Subject: Modification 7 Precinct Village and Carpark (SSD-9835-Mod-7)

Thank you for your email received 24 January 2022 requesting comments on the Response to Submission (RtS), dated 17 December 2021, for the above proposal. Environment, Energy and Science Group (EES) has reviewed the proponent's response to EES's submission.

Figure 8: 1% AEP flood depth afflux map, showing impact of Precinct Village and Car Park

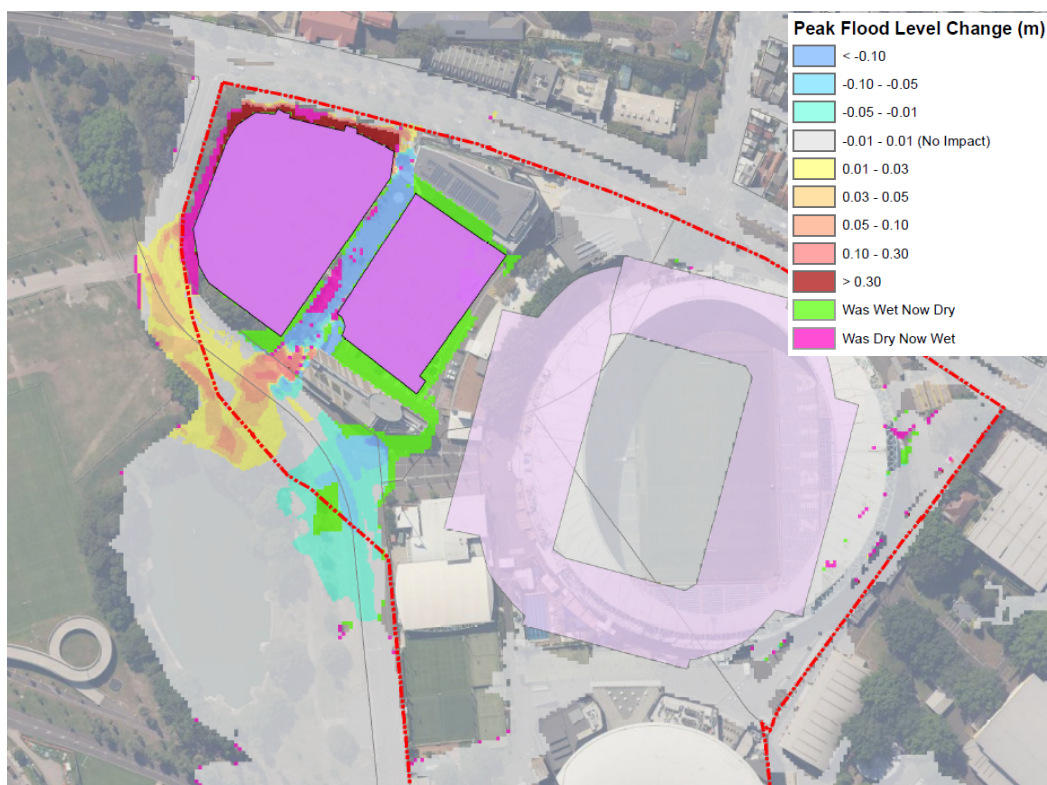
- the figures in Appendix G of the RtS need titles and it is not clear what they represent
- there are only three figures presented in Appendix G, presumably showing hazard. The RtS states afflux figures were provided, but they are not available at Appendix G. Figures as per the original report should be updated, including depth/level and afflux
- the RtS does not demonstrate that "no worsening of hazard on the central driveway" has been achieved, but in fact indicates the opposite. EES therefore strongly recommends that clear documentation is provided to justify this conclusion.

It is standard practice to provide evidence that the design solution achieves the required objectives. EES considers that an updated report should be produced, documenting the new design solution, and including updated figures, is required to appropriately assess the potential for and severity of flood impacts.
